Our Reference: NSW211526

17 May 2022

**Re: Nepean Hospital Redevelopment Project - Stage 2
SSDA Response Letter – Civil Works**

Figure 21 - Proposed Drop-off area and access driveways

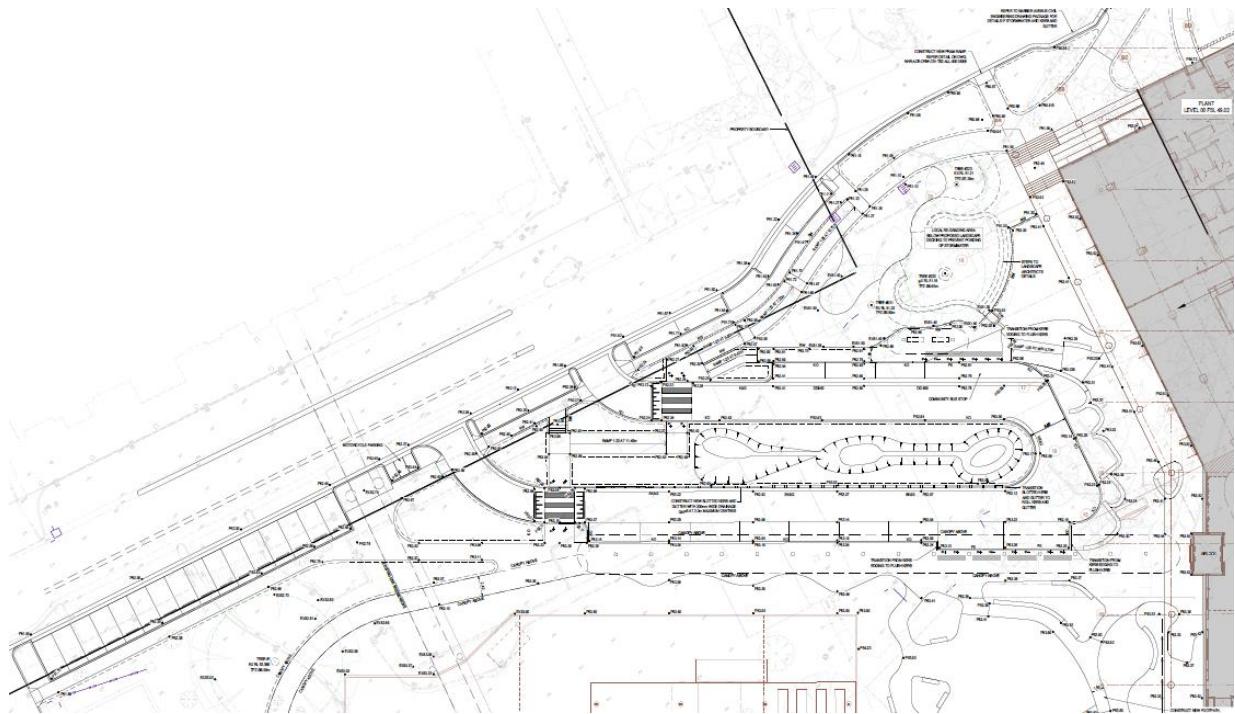
Penrith City Council's major Civil comments to the SSDA design relate to the removal of existing Barber Ave on-street public parking and the proposed Hospital intersection configuration off Barber Avenue being a Y-shaped entry arrangement rather perpendicular, as shown in the image below.

The project team has proposed the below reconfiguration of the front entry layout as an outcome of these discussions. This revised layout is intended to provide perpendicular entry and exit points to Barber Avenue and reinstate 22 of the public on-street lost due to the development, as requested by Council, whilst reducing the impact on the amenity front entry amenity of the Hospital front entry drop off. Further information regarding the parking response can be found in the Traffic Engineering response letter completed by PTC.
